Recommendation Report for Outline Consent

REF NO: WA/33/18/OUT

LOCATION: Spindlewood
Yapton Lane
Walberton
BN18 0AS

PROPOSAL: Outline application with some matters reserved for the demolition of existing dwelling & erection of 5 No. dwellings. This application is a Departure from the Development Plan.

Drawing.
Proposed Site Plan
showing Swept Path Path
and Parking Provision

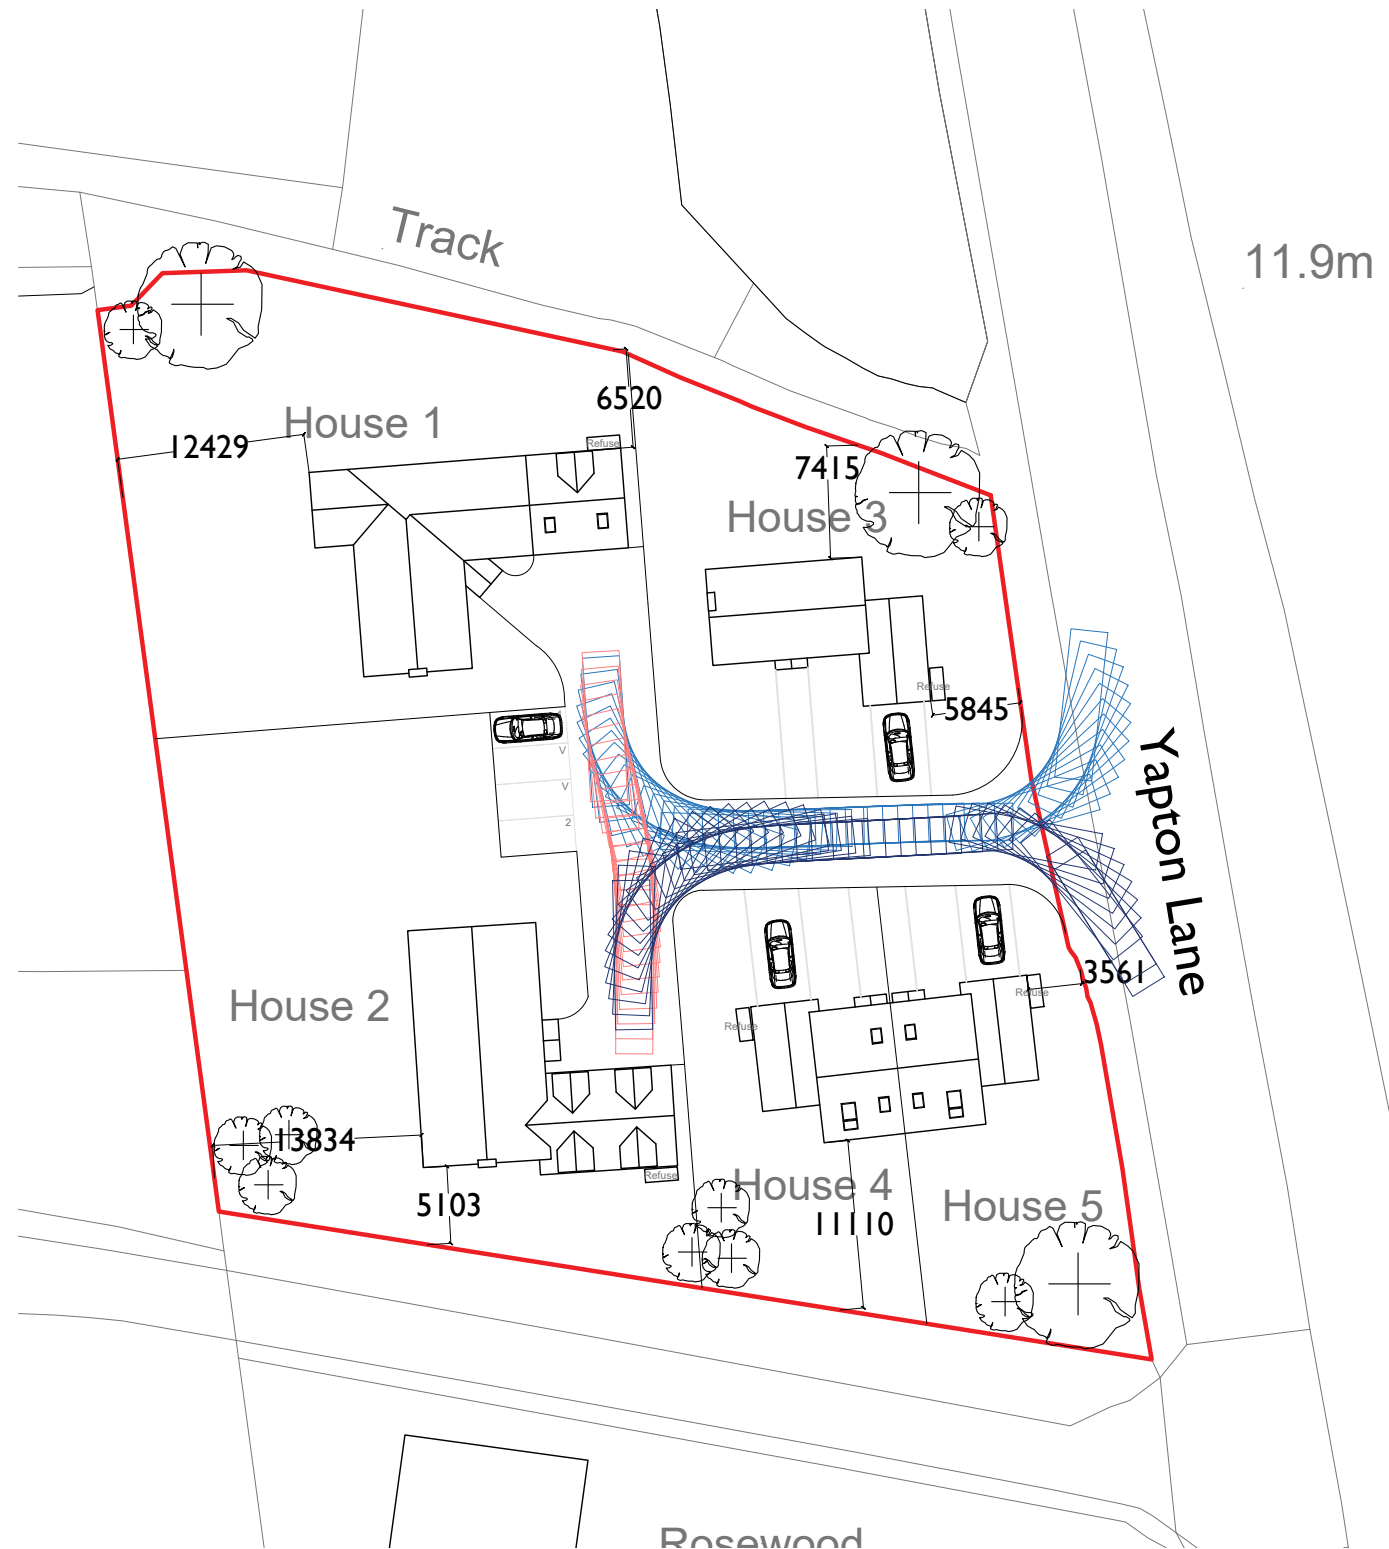
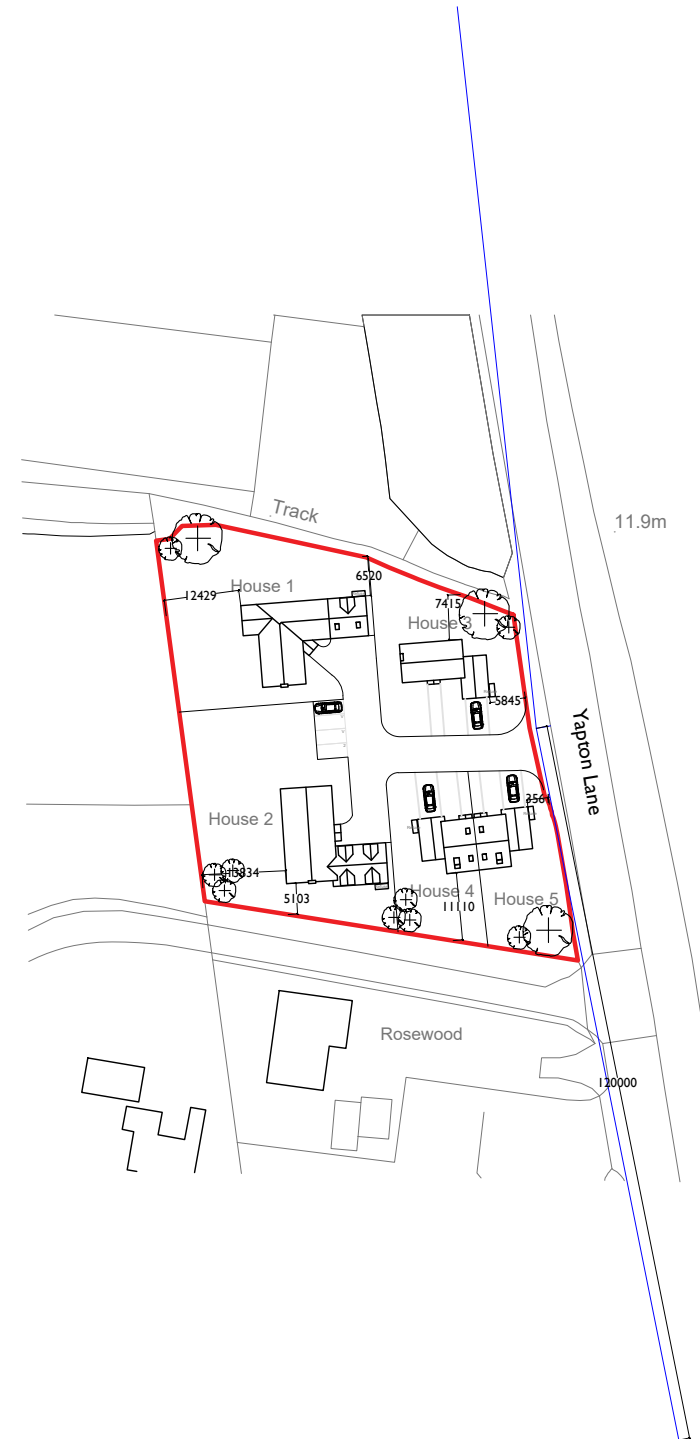
WSCC require further information regarding the outline application for 5 dwellings.

1. Speed Survey.
2. Updated drawing to show visibility splays from new access location/existing access to compare the changes.
3. Car parking strategy.
4. Layout issues addressed.

Supplementary plans submitted and highways are satisfied with access and splays. They have confirmed that a speed survey is not required.

The application has been assessed by WSCC Highways. Following the submission of supplementary plans WSCC advice that it is satisfied with the proposed access and associated visibility splays.
